**Our ref:** NO/2025/116706/01-L01  
**Your ref:** 3/2025/0147

**PROPOSED DEMOLITION OF EXISTING BUILDINGS AND ERECTION OF SIX 2-BED AND ONE THREE-BED APARTMENT BUILDING TOGETHER WITH A TWO STOREY BUSINESS CENTRE AND ASSOCIATED PARKING AND BIN STORE. PEEL STREET BUSINESS ESTATE, PEEL STREET, CLITHEROE, BB7 1RA**

The application is accompanied by a Flood Risk Assessment (FRA) entitled 'Flood Risk Assessment and Drainage Strategy' (Document Ref: 24.1528, Date: August 2024) prepared by REFORD Consulting Engineers Limited.

PROPOSED ELEVATIONS
Scale: 1:100@A1

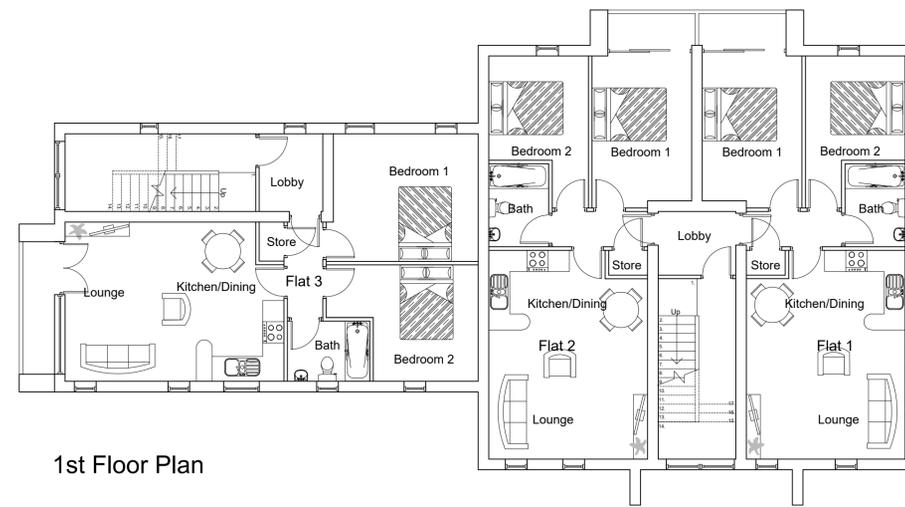
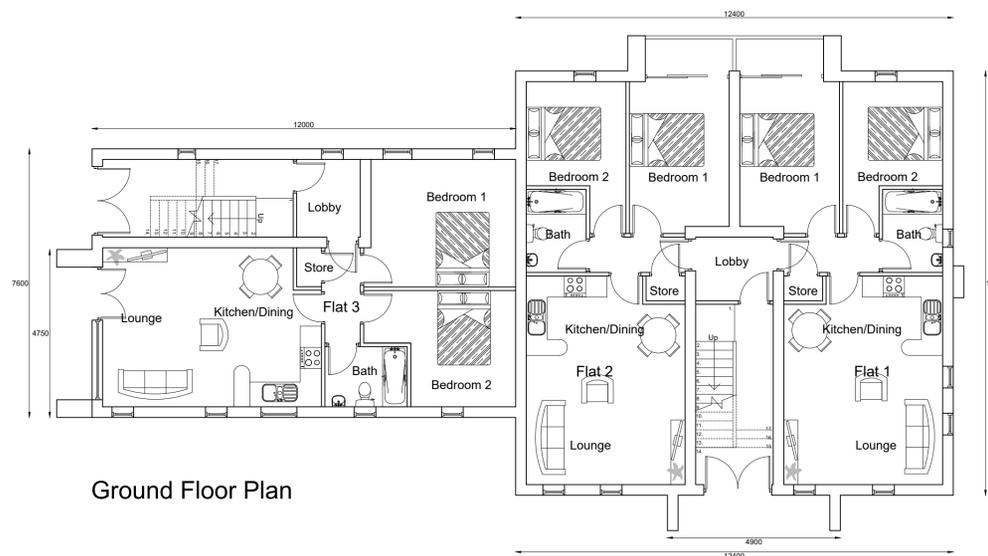
Finished Floor Levels (FFL's) have currently been proposed in relation to the 1% Annual Exceedance Probability fluvial event, plus a 35% climate change allowance, from the Mearley Brook 2018 Environment Agency hydraulic model. The correct peak river flow climate change allowance to use for this development is the 2080s central Ribble management catchment allowance of 36%. Using a lower climate change allowance than advised in the guidance referred to above increases uncertainty to some extent – this increases the need to raise FFL's towards 600mm above design flood level/average ground level/adjacent road level.

The Environment Agency's Mearley Brook 2018 hydraulic model shows that the flood outline for the defended 1% Annual Exceedance Probability event (plus 35% climate change) does affect the northern residential “Building 1” – at least at its western/southern reaches. This implies that current ground levels at the land surrounding the northern building may be lower than 74.64m AOD - given that the incorrect peak river flow climate change allowance has been relied upon, design flood levels may be higher than this level.

- Plan and sectional drawings which clearly states the distance from the top of the riverbank to the development at its closest point, based on topographical survey data, including any boundary fencing or walls. They should demonstrate that a minimum of 8 meters is left unobstructed and that Environment Agency access to and along that watercourse is not impeded.
- A revised FRA which addresses the points highlighted in our objection above. If this cannot be achieved, we are likely to maintain our objection. Please consult
